City of Portland, Maine – Building or Use Permit Application 389 Congress Street, 04101, Tel: (207) 874-8703, FAX: 874-8716

Location of Construction: * 30 Dayton Street, 04103		Owner: Charles & Janice Shannon *		Phone: 797-6058		Permit No: 000488	
Owner Address: 30 Dayton Street, 04103		Lessee/Buyer's Name:		Phone:			Permit Issued:
Contractor Name: Scott Proctor		Address:		Phone:		Zone: R-3 CBL: 339-C-015 Zoning Approval: OK - 5/16/00 Special Zone or Reviews: <input type="checkbox"/> Shoreland N/A <input type="checkbox"/> Wetland <input type="checkbox"/> Flood Zone <input type="checkbox"/> Subdivision <input type="checkbox"/> Site Plan maj <input type="checkbox"/> minor <input type="checkbox"/> mm <input type="checkbox"/>	
Past Use: Single family dwelling		Proposed Use: SAME		COST OF WORK: \$ 3,000.00			PERMIT FEE: \$ 42.00
Proposed Project Description: Building 31' x 23 1/2' deck- wrapped around rear side of house.		Signature:		FIRE DEPT. <input type="checkbox"/> Approved <input type="checkbox"/> Denied		INSPECTION: Use Group R-3 Type 5B BOCA 99 Signature: <i>[Signature]</i>

BUILDING PERMIT REPORT

REASON FOR PERMIT: 6 1/2' x 21' deck 5' x 31' deck

SITE PLAN

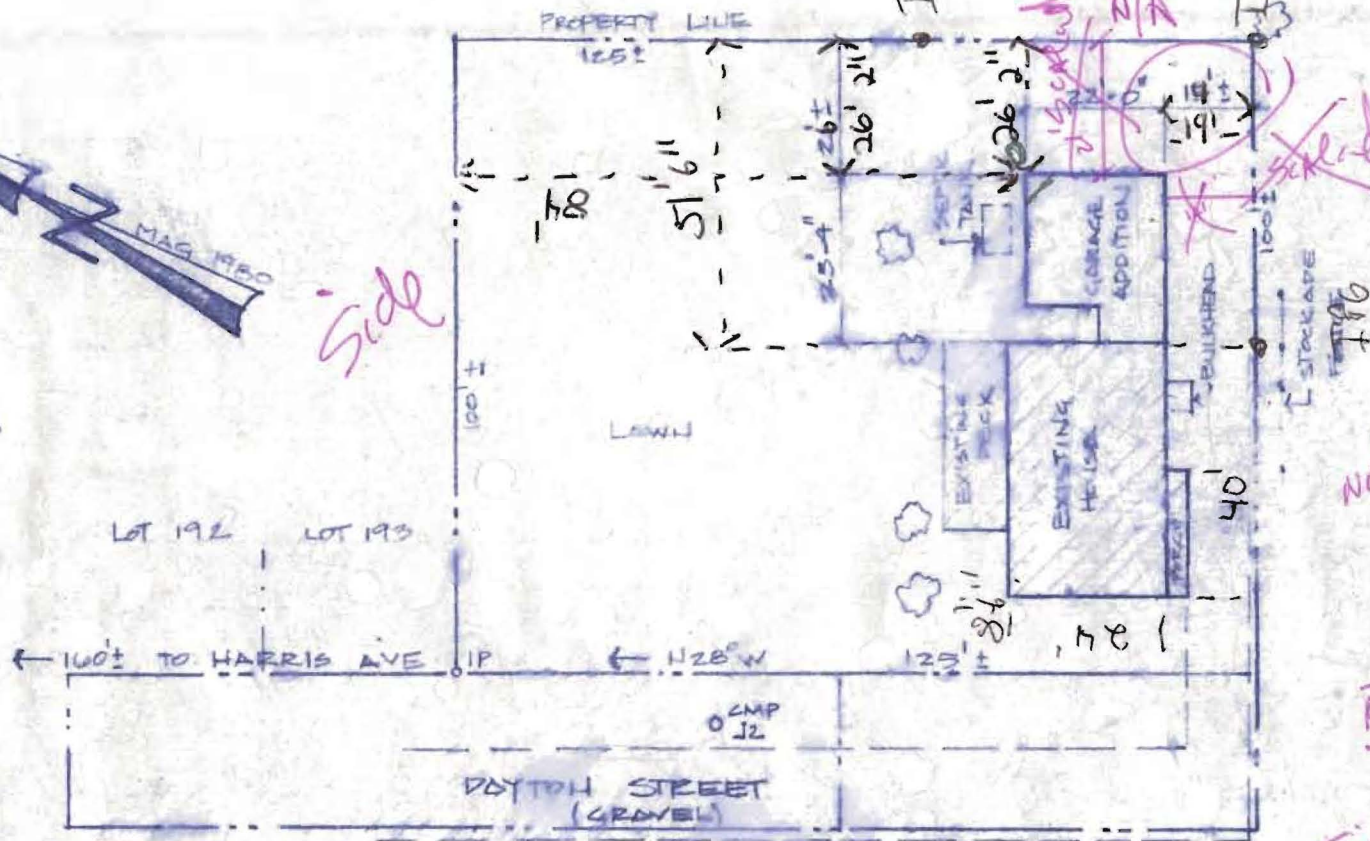
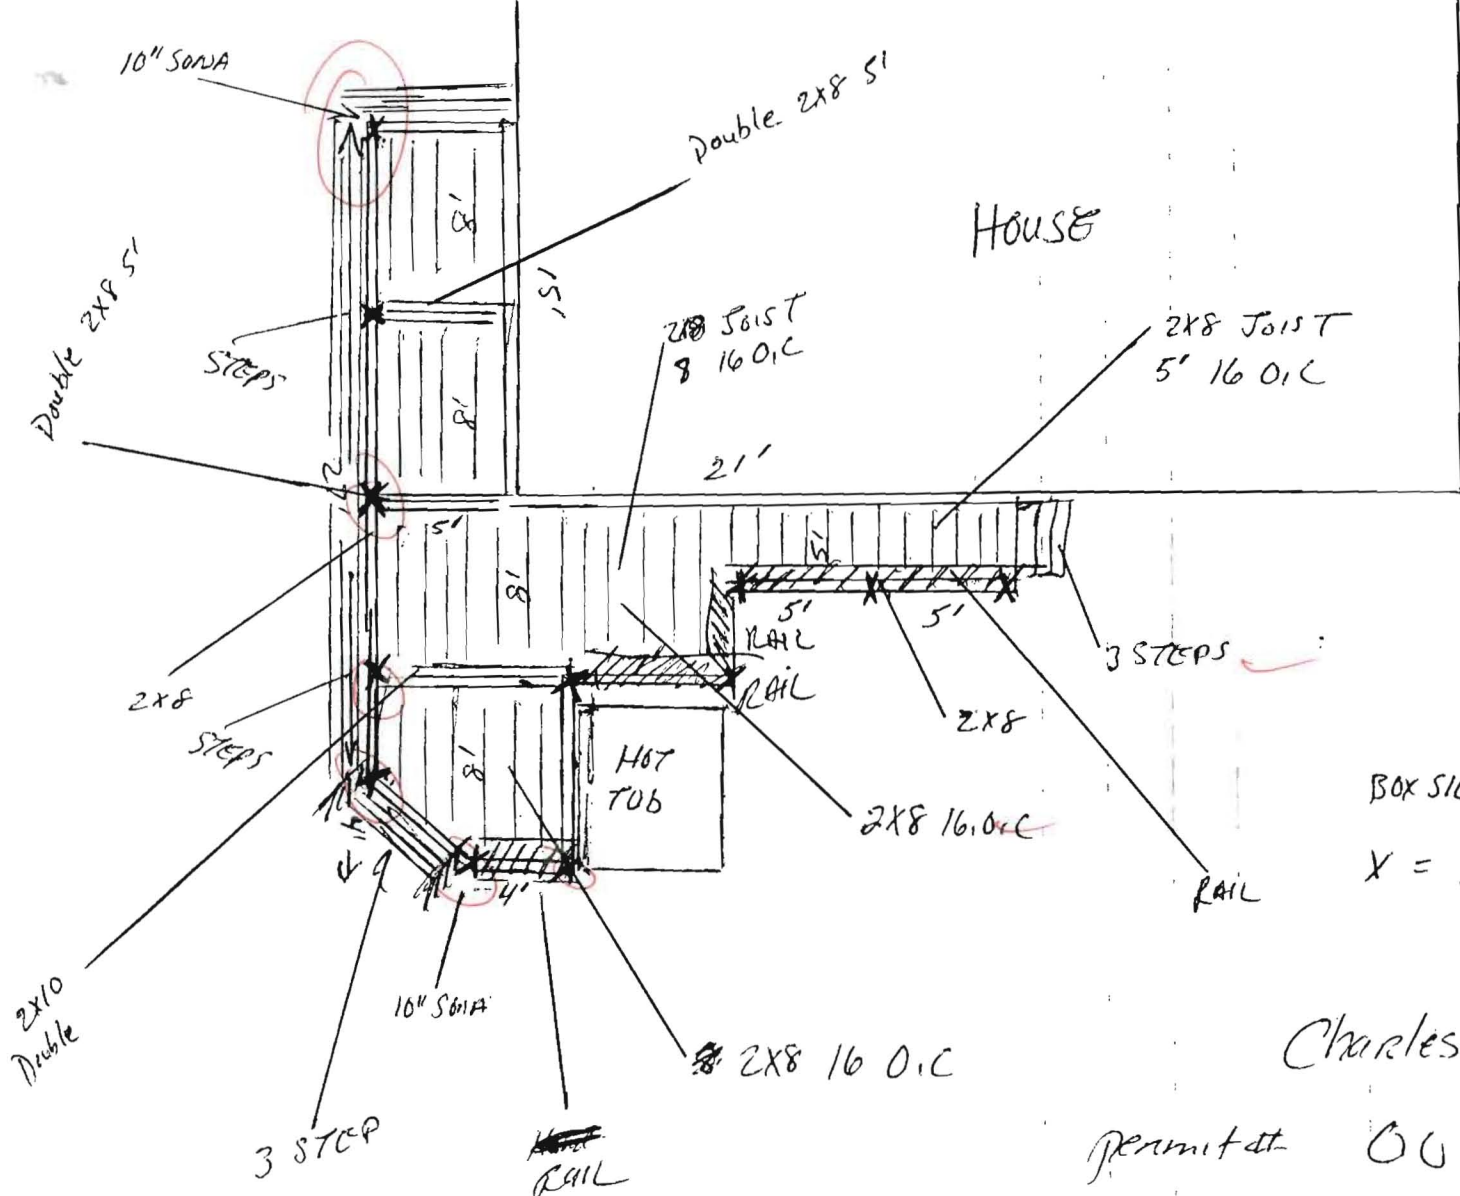
R-3 Zone
 front: 25' req - 41' shown
 sides: 8' req (1 story) - 14' + 280' shown
 fence: 25' req - 2 x 35' + 8' shown
 where the Decks
 b/c 5/16/00
